## City of Albuquerque

September 28, 1982

RE: VAUGHAN COMPANY OFFICE BUILDING DRAINAGE PLAN

SHEET NO.
C 1

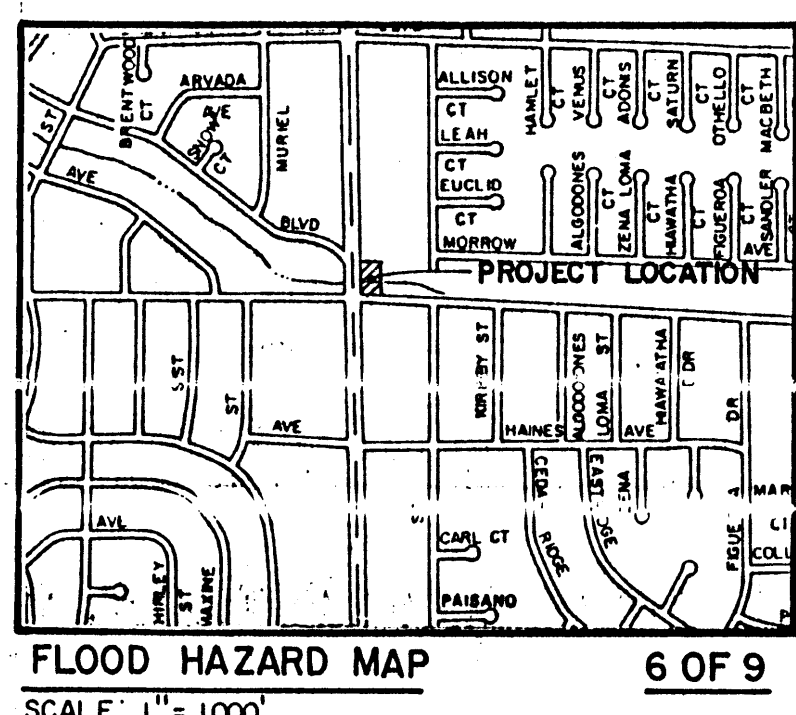
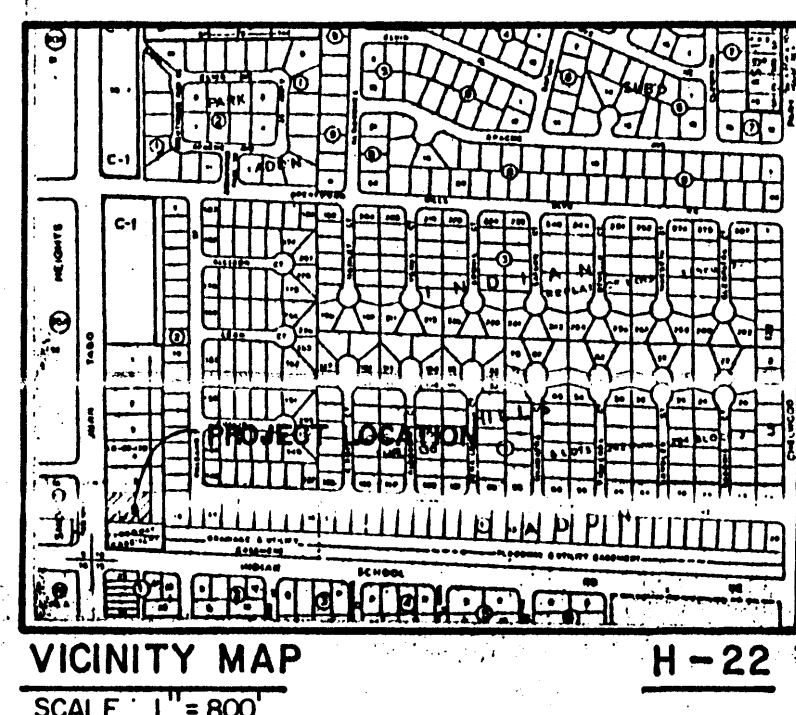
I am in general agreement with the proposed drainage scheme for the referenced project. However, I am abit concerned about the proximity of the entrance way to the arroyo crossing. As you know, this particular reach of the channel will not be improved under the East Arroyos V Contract. Therefore, it maybe appropriate to provide some bank protection to insure the integrity of the entrance way.
